DEVELOPMENT REVIEW BOARD  
TRANSPORTATION DEVELOPMENT

DRB Project Number: 1011599  
Alvarado Greens Unit 1

SUBJECT: Sketch Plat

DATE: April 18, 2018

PLAT OF  
**LOTS 8-A & 8-B**  
**UNIT 1**  
**ALVARADO GARDENS**  
 WITHIN  
 TOWN OF ALBUQUERQUE GRANT  
 PROJECTED SECTION 18, T.10N., R.3E., N.M.P.M.  
 CITY OF ALBUQUERQUE  
 BERNALILLO COUNTY, NEW MEXICO  
 MARCH, 2018

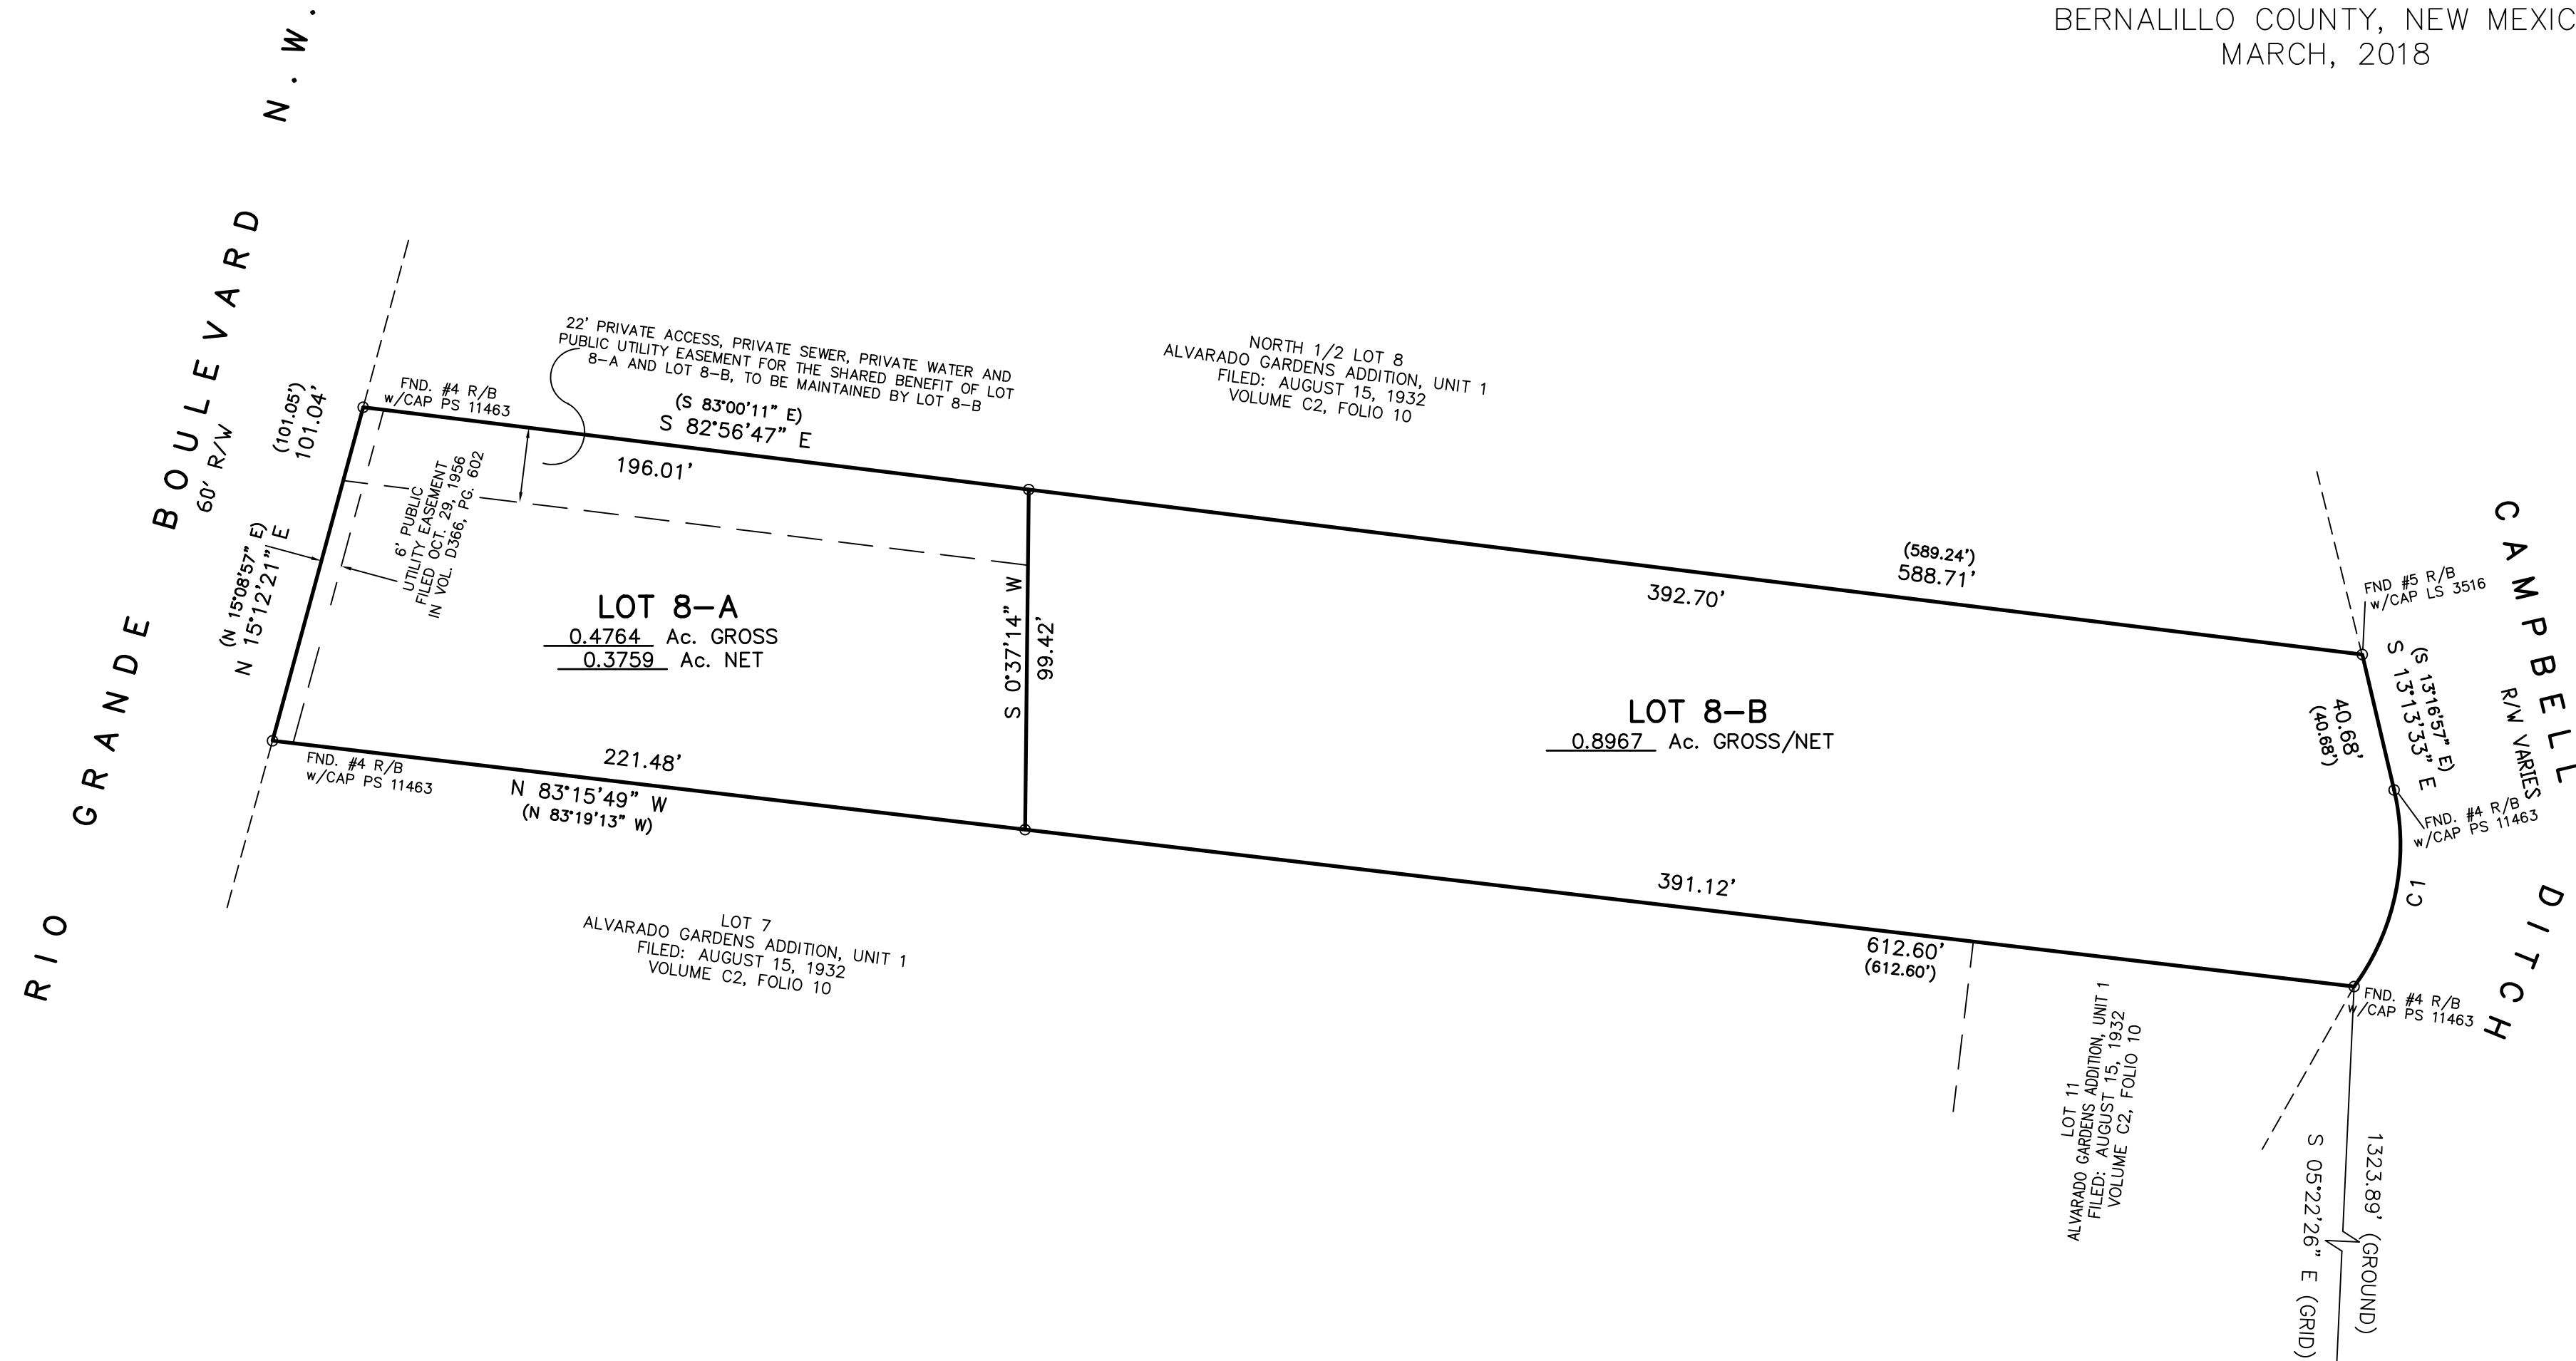
- Must add a signature line for Code Enforcement
- No objection to the replat.

PLAT OF  
**LOTS 8-A & 8-B**  
**UNIT 1**  
**ALVARADO GARDENS**  
 WITHIN  
 TOWN OF ALBUQUERQUE GRANT  
 PROJECTED SECTION 18, T.10N., R.3E., N.M.P.M.  
 CITY OF ALBUQUERQUE  
 BERNALILLO COUNTY, NEW MEXICO  
 MARCH, 2018

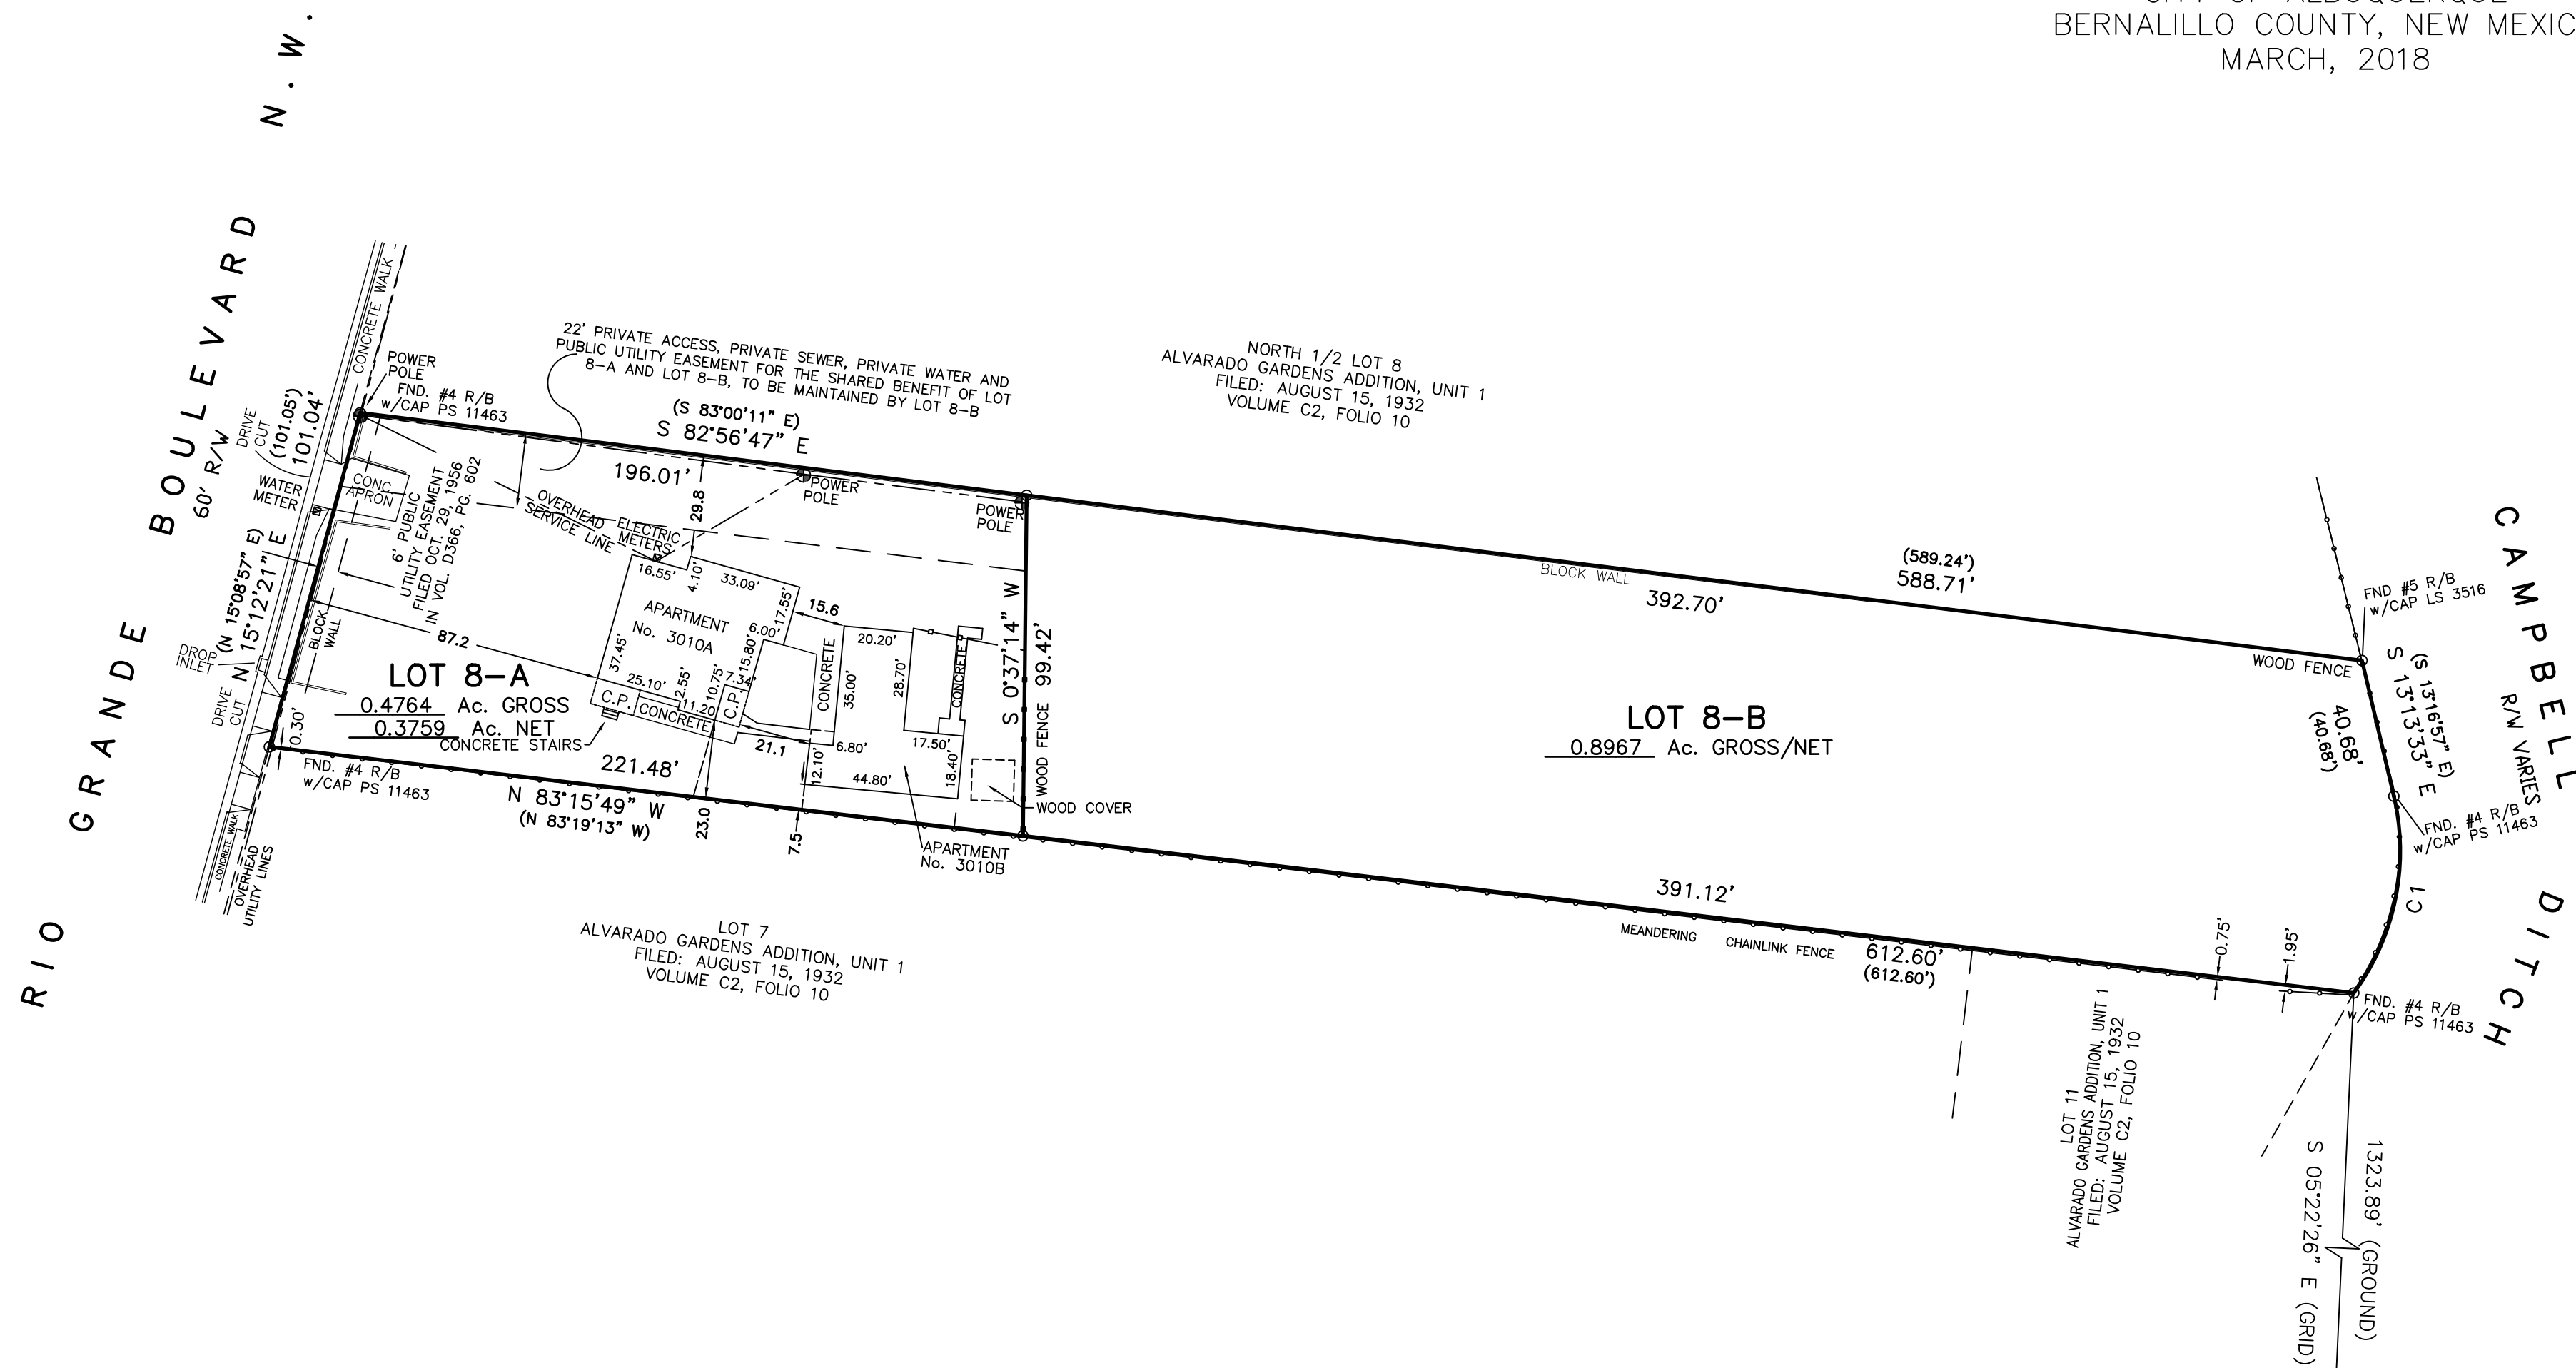
1. Line up access easement with existing driveway.
2. For final plat, any access easements need to be shown with all beneficiaries and maintenance responsibilities listed.
3. 22' gravel access road is required for access to lot 8-B.
